From: Wayne Jones <wayne.jones@dpi.nsw.gov.au>
Sent: Monday, 25 May 2015 3:31 PM
To: Pamela Morales
Subject: Car Wash Facility, Kooragang (DA 6988) SEE

**Car Wash Facility, Kooragang (DA 6988)
Response to exhibition of Statement of Environmental Effects**

The NSW Office of Water (Office of Water) has reviewed the Statement of Environmental Effects (SEE) for a proposed car wash facility at 130 Cormorant Road, Kooragang and provides the following comments:

Project  
**KOORAGANG CAR WASH**  
 Part Lot 1 DP 1195449 - 130 CORMORANT ROAD Cnr. EGRET STREET  
**KOORAGANG NSW**  
 FOR  
**SOVECHLES DEVELOPMENTS Pty Ltd**  
 Drawing Title  
 CAR WASH POLLUTION CONTROL SCHEMATIC

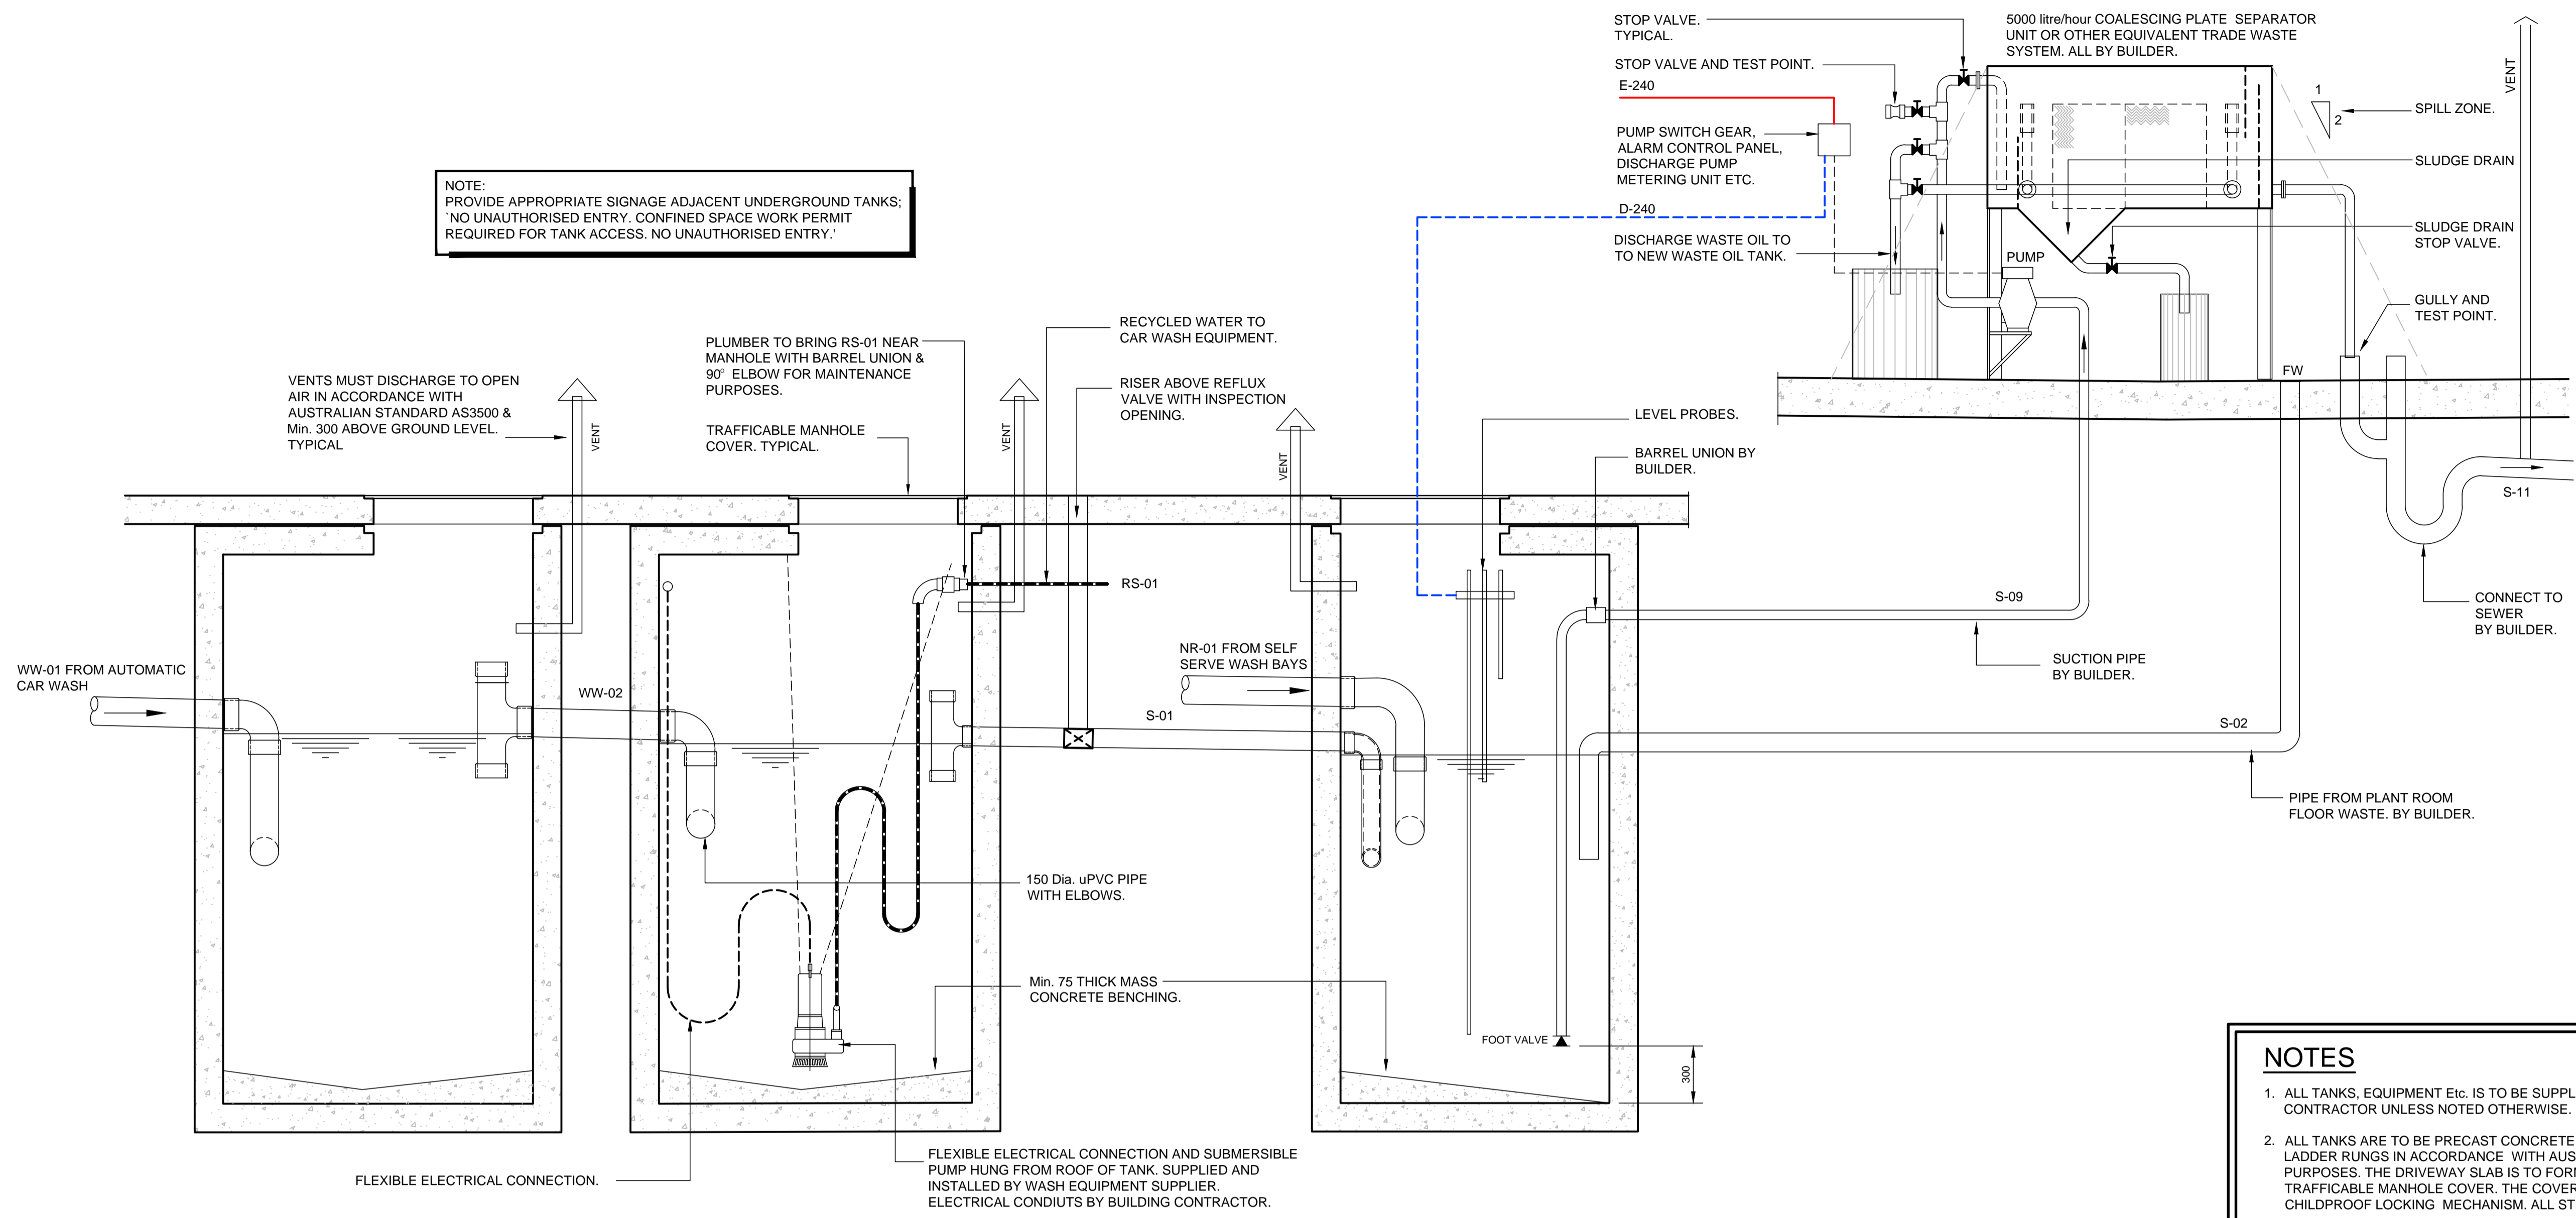
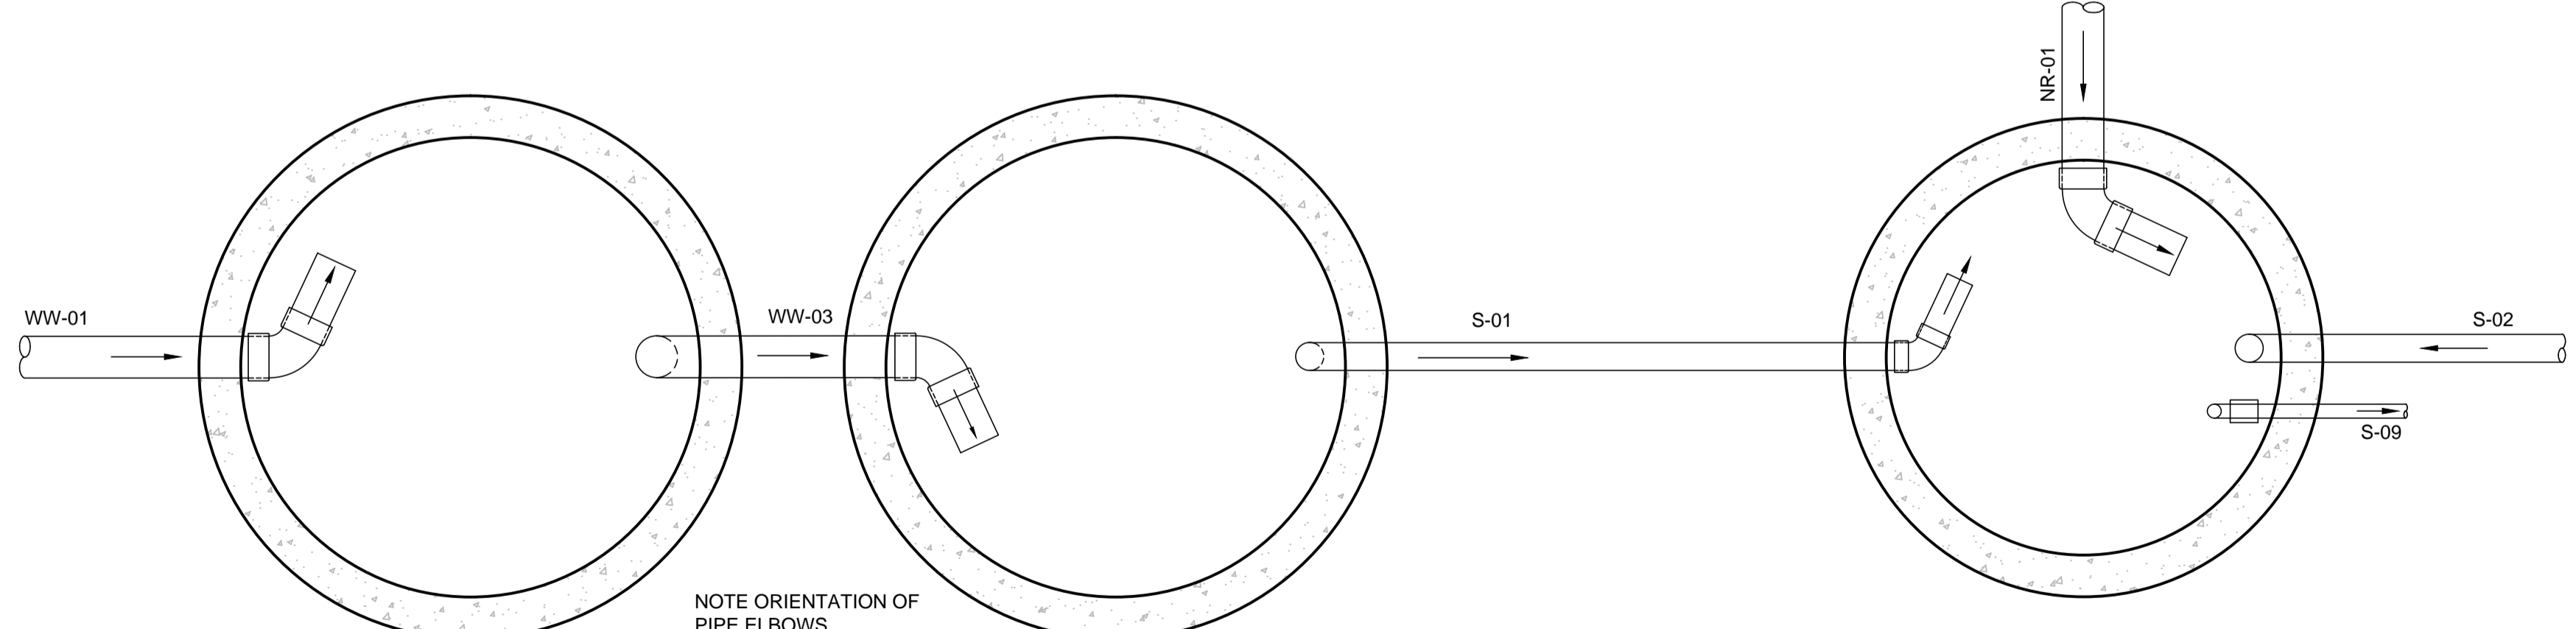
- The SEE outlines the development is designed for the efficient use and management of water, with much of the water utilised recycled for re-use in the facility. The SEE outlines rainwater will be captured for use in the car wash facility to reduce water consumption. There will be two tanks located underground which will serve as settlement and recycling tanks. A third tank will function as a sewer discharge pit for car wash waste water.

The SEE outlines the total water consumption per day would be 6050 litres. It is unclear from the SEE if the rainwater collected will be adequate to service the facility or whether

water will need to be sourced elsewhere such as from town water supply or if the proponent has a licence to access groundwater or surface water. This should be clarified.

- Whilst the Office of Water is not a point source regulator for groundwater contamination, it is recommended Newcastle City Council and the Environmental Protection Authority, are contacted to determine their requirements in relation to the proposed development, particularly in relation to the sewer discharge pit.
- It is unclear from the SEE, if there is the potential to intercept groundwater during the construction phase of the facility. This should be clarified.
